From: John [REDACTED]
Sent: 29 July 2019 11:11
To: Zac Denton <Zac.Denton@arun.gov.uk>
Subject: RE: LU/131/19/PL & LU/132/19/L

Subject: LU/131/19/PL & LU/132/19/L

Drawing title
Proposed Changes

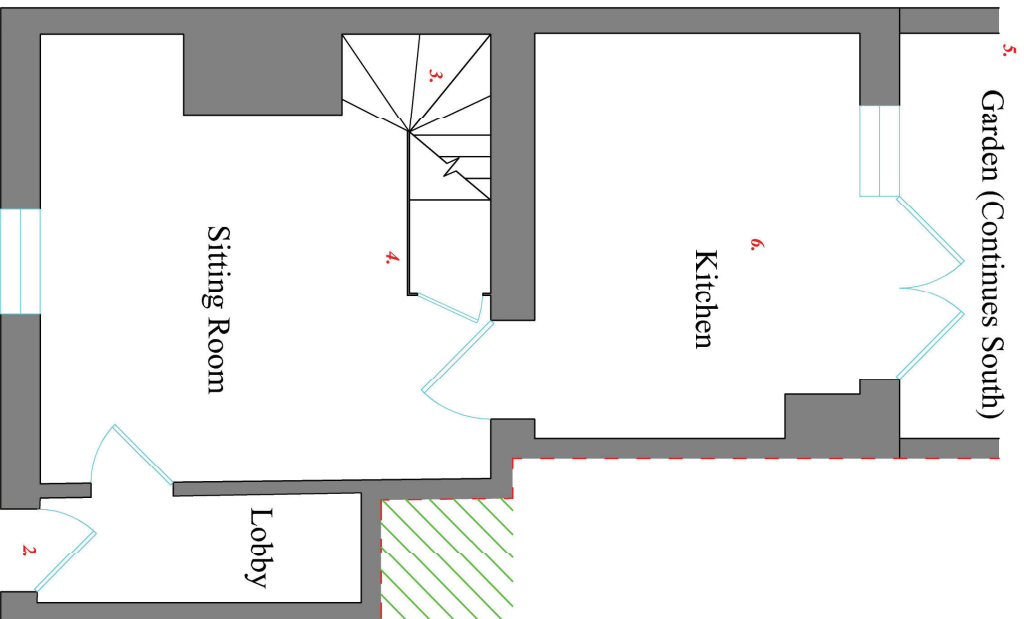
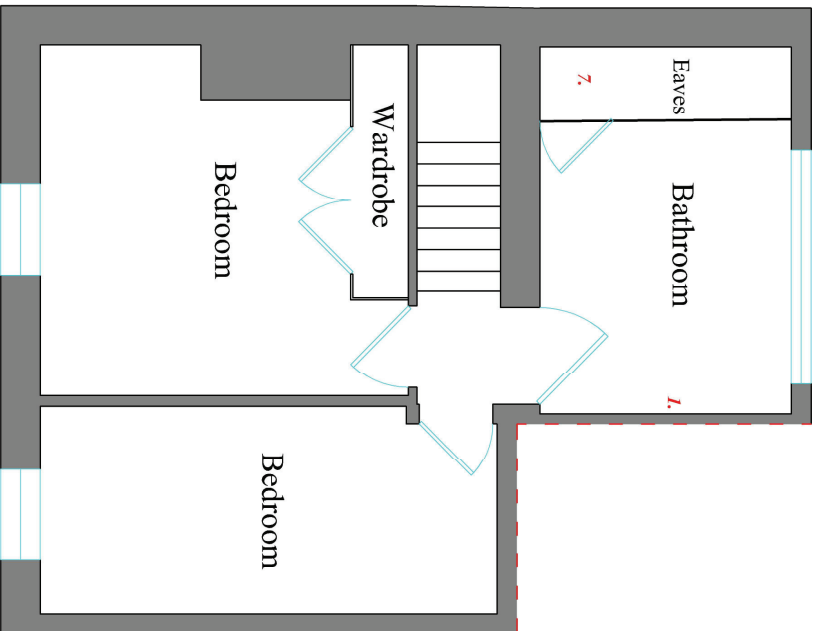
Regarding the above planning application, are you able to confirm as to whether you intend to repoint the entire elevation of the dwelling, or more than this?

We will only repoint where necessary, there are a number of cracks to the front elevation and these are to be repaired and repointed.
